<b>Environmental Health Consultation Response</b>		<b>Officer</b>	<b>Ken Robinson</b>	
<b>Detail: Construction of 10 bay covered driving range building and associated t</b>		<b>Flare SRU:</b>	<b>043590</b>	
<b>Address:</b>	<b>Clitheroe Golf Club Whalley Road Barrow Clitheroe Lancashire BB7 1PP</b>		 <p>Ribble Valley Borough Council <a href="http://www.ribblevalley.gov.uk">www.ribblevalley.gov.uk</a></p>	
<b>Application Ref:</b>	3/2020/0142	<b>Case Officer:</b>		Ms Rebecca Bowers
<b>Response Ref:</b>	3/2020/0142/ENV/01	<b>Issue Date:</b>		27 April 2020

1.3.6 Pseudo colours, Lightspill area (E)

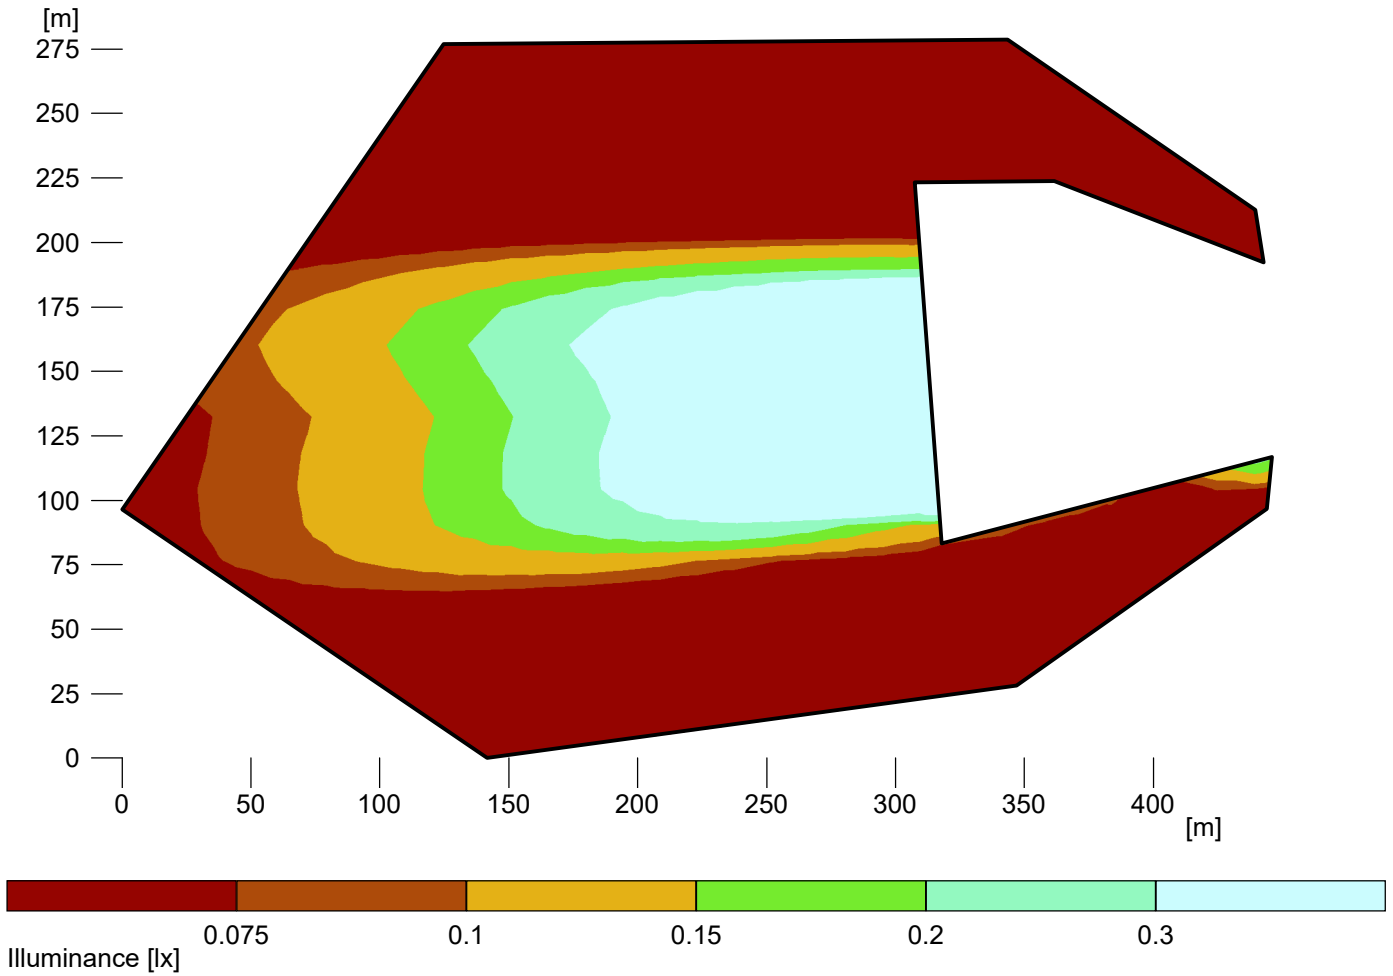
<b>General Comments/Observations</b>	
<b>1.1</b>	Light pollution can give rise to a Statutory Nuisance under the Environmental Protection Act 1990.
<b>1.2</b>	The applicant has not submitted adequate updated details of the lighting proposals or any controls, through design or usage, to limit the effect of lighting on nearby dwellings or on the local ecology. The update from Luminata provides no background data as to how their revised assessment was reached and provides no assessment of light spillage over the wider area or the effect on wildlife.
<b>Suggestions/Mitigation</b>	
<b>2.1</b>	Due to the revised height and location of the driving range structure (and therefore the likely alteration in positioning of lighting), the applicant should procure an updated lighting impact assessment, and in consequence of this submit details of how a light pollution nuisance will be avoided
<b>Conclusions/Suggested Conditions</b>

<b>2.2</b>	The above observations have been provided on the basis of the level of information submitted and the comments contained within this response represent officer opinion only, at the time of writing, without prejudice.
<b>2.3</b>	Should you be minded to approve the application, notwithstanding other considerations, I would suggest that the following conditions be attached should you feel they are relevant and justified:  Condition 01 The lighting should comply with industry best practice in the design and construction of the lighting units.  Condition 02 The hours of operation should be limited to 09:00 to 21:00 to minimise the impact of the lighting.
	<b>Officer:</b>
	<b>Michaela Gleave</b>
